Recommendation Report for Listed Building Consent for Alterations, Extension or Demolition of a
Listed Building

REF NO: PO/8/21/L

LOCATION: Peckhams
Poling Street
Poling
BN18 9PT

PROPOSAL: Listed building consent for the renovation of stable block to create a single storey timber framed barn style building for home office use with lean-to extension.

DRAWING NUMBER
1460 P 002

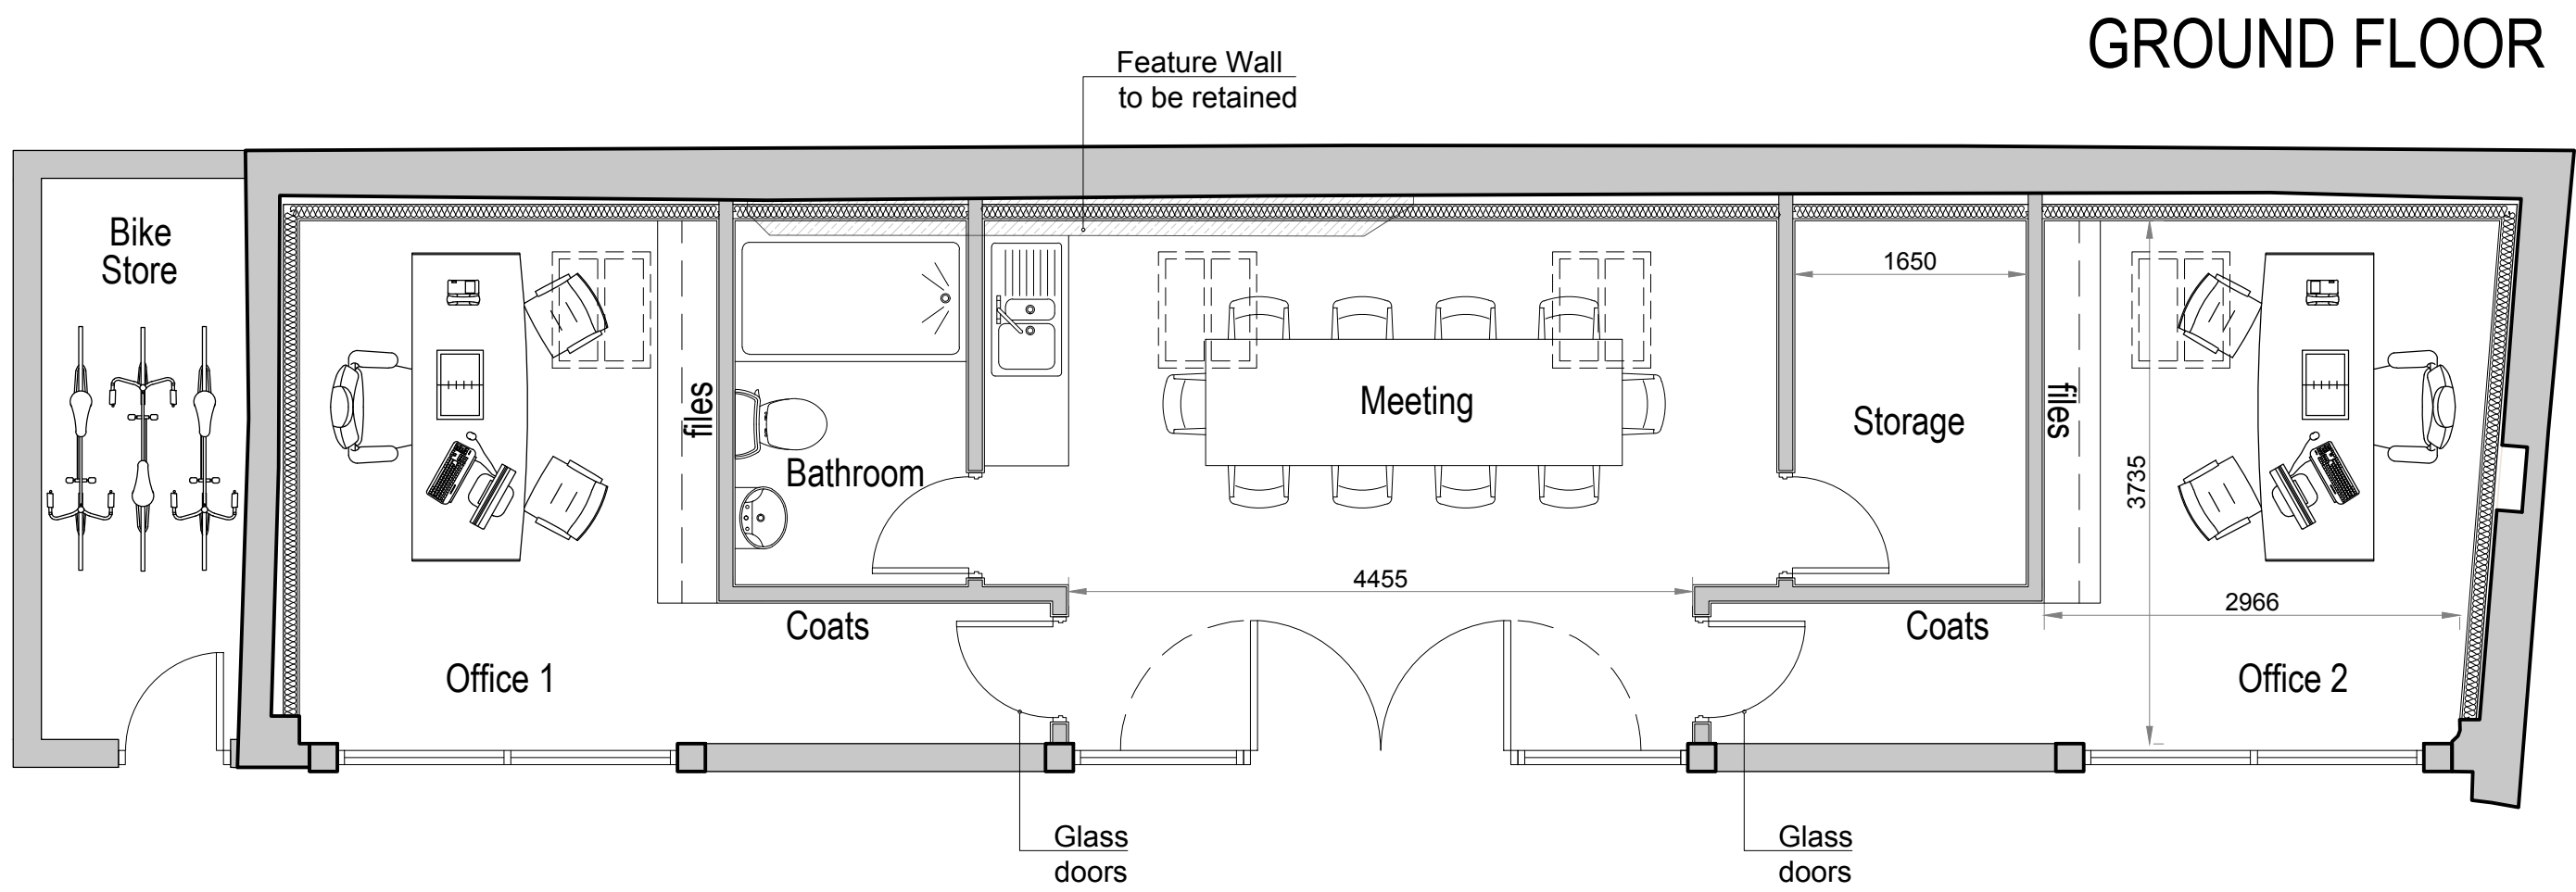
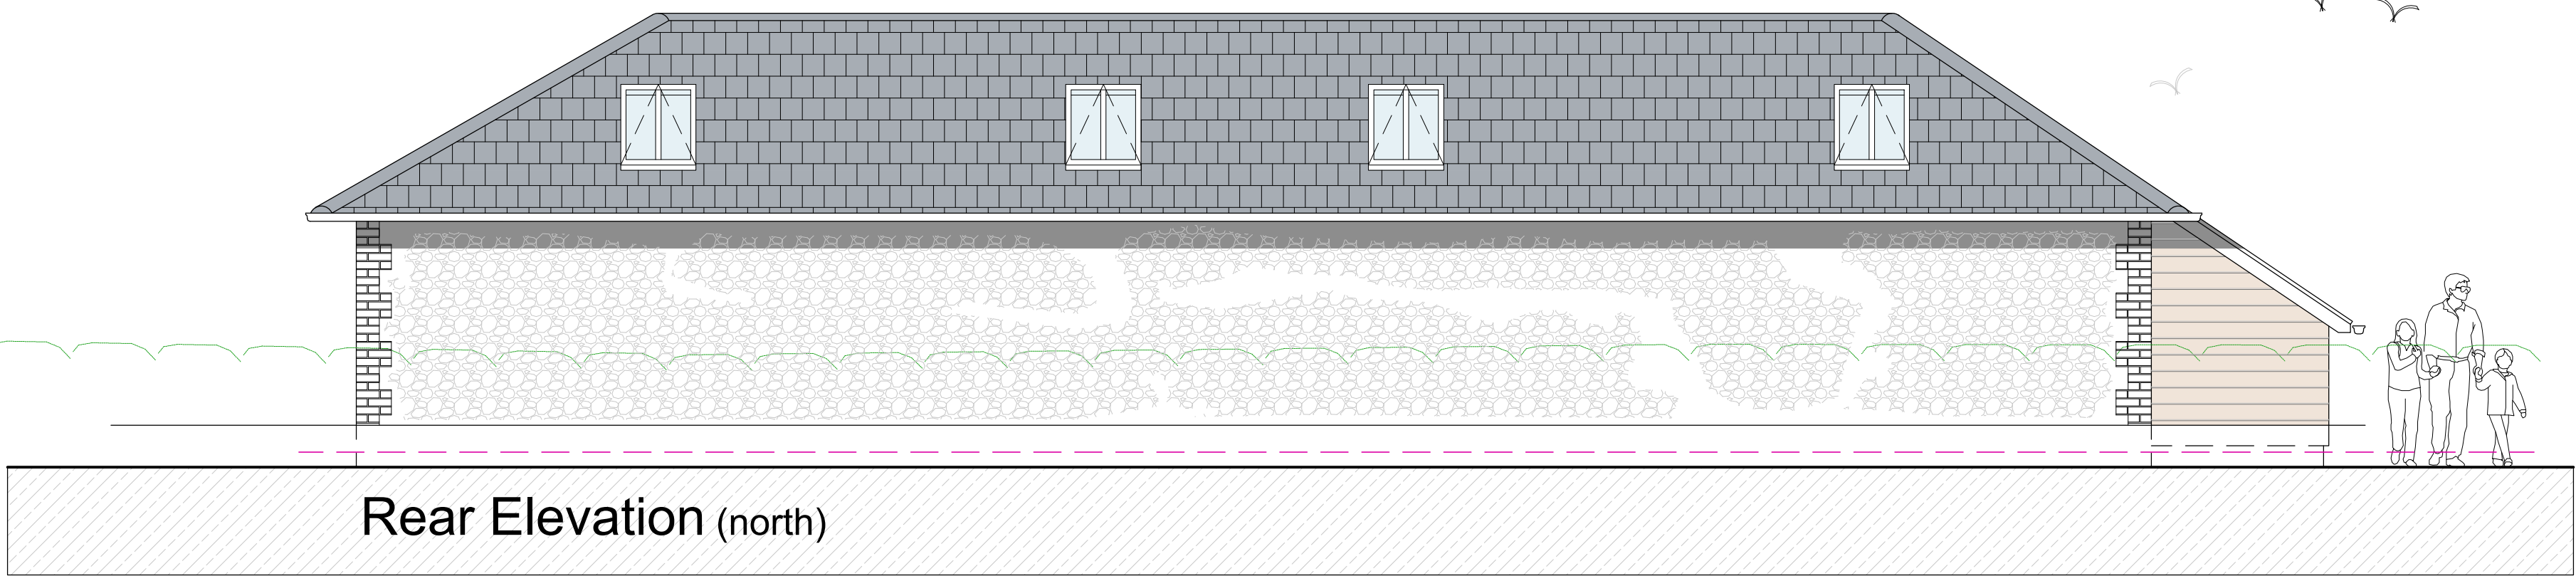
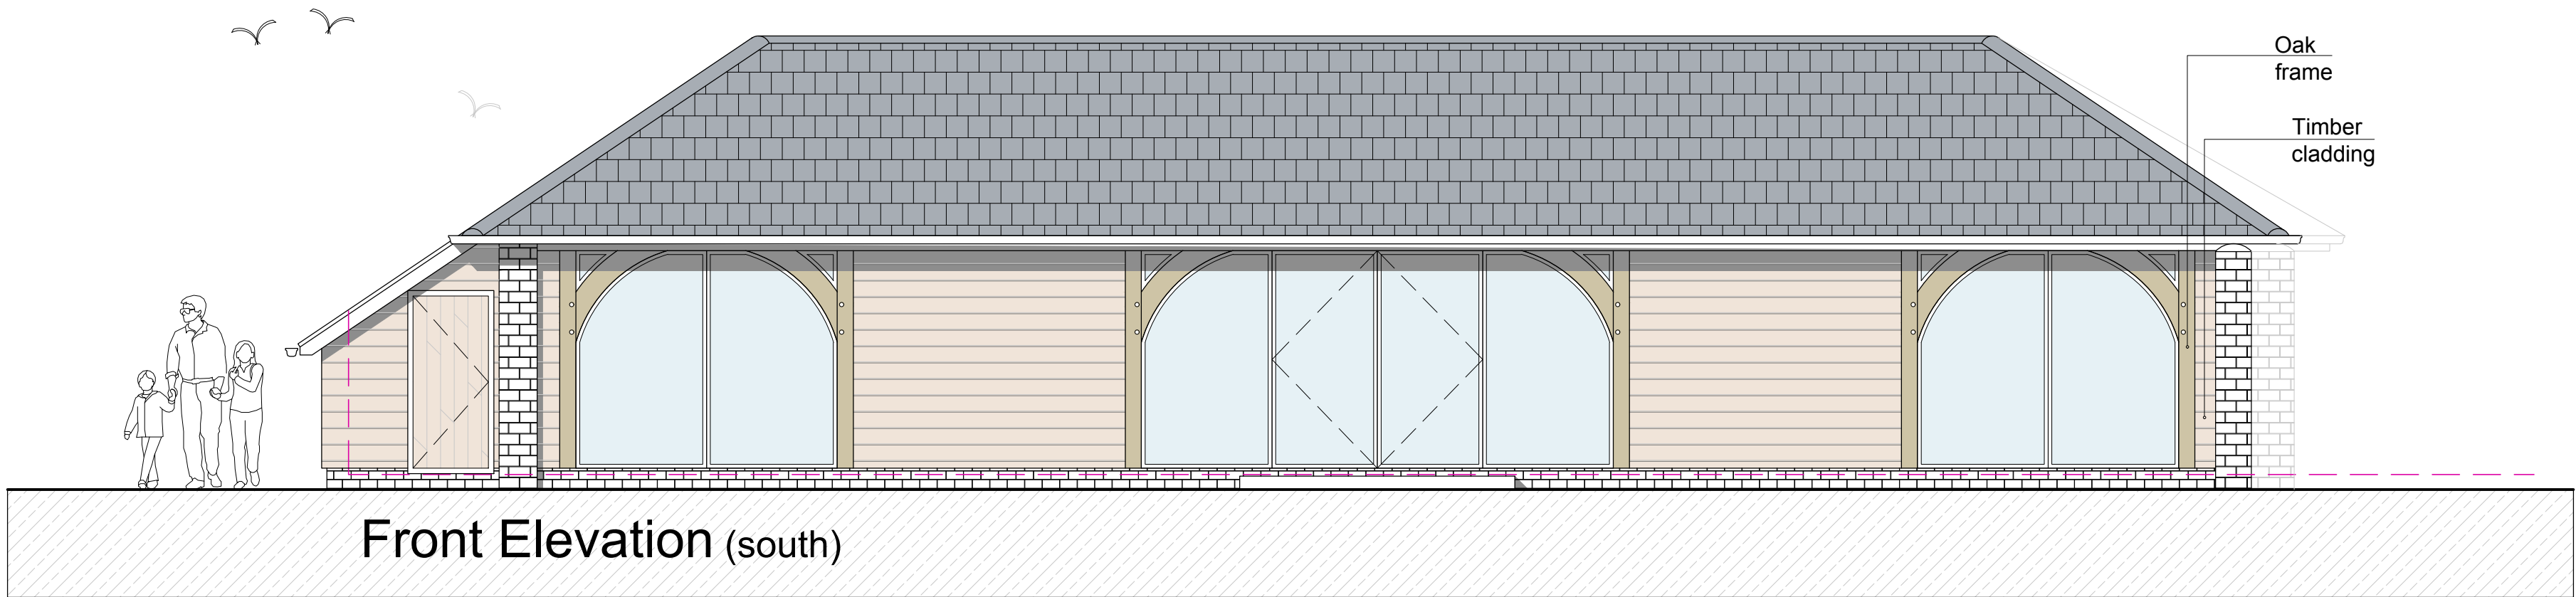
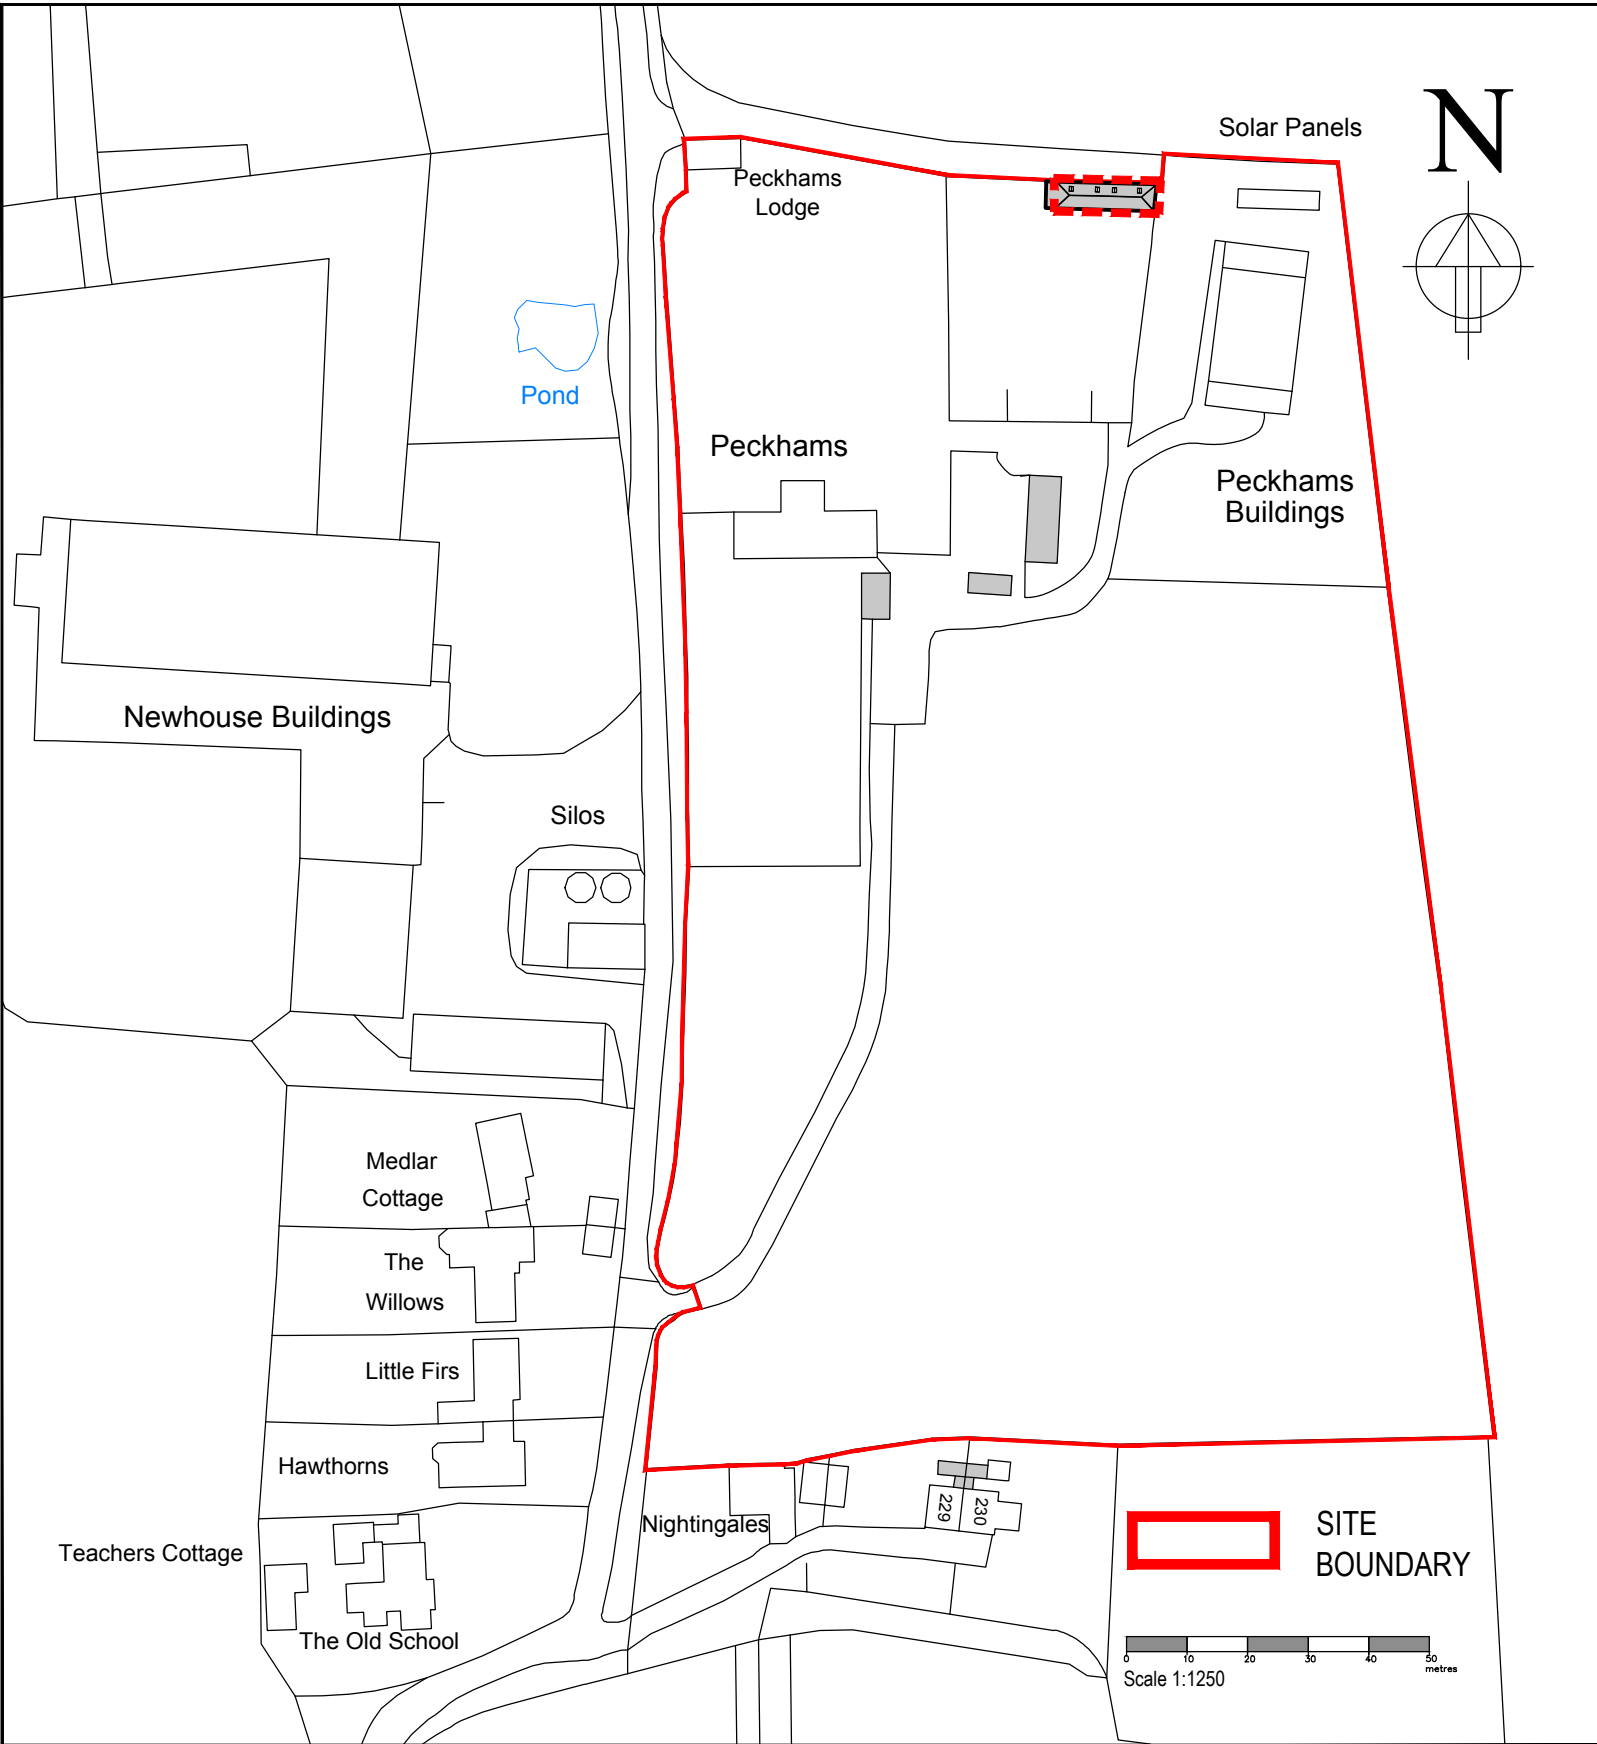
The proposed retention, refurbishment and re-use of the building is positive. It is also positive to see that the intention is for the front elevation to remain fairly simple in appearance with three openings. However, clarification is required regarding the retained timber frame to the front elevation and if the existing staddle stones will be re-used. It would help to understand how the wood is to be treated, and further details of the windows/doors. Details of both of these can be provided for by way of condition. The proposed internal alterations appear to be reversible and are therefore acceptable. It would help to understand if the rooms are to be left open to the roof void. The addition of the bike store is carefully considered and will not harm the significance of the structure. My suggestion would be that the former external wall is left untreated so that it can still be seen/understood.

Careful consideration would also need to be given to any potential landscaping which could be necessary in order to facilitate such a use. I am thinking of the need for any hard standings or pavements and planting.

Comments noted. Additional plans have been submitted detailing the retention of the straddle stones and referencing relocation of timber panels in order to accommodate the large central glazed area and a cross section to identify that the roof area is to remain open.
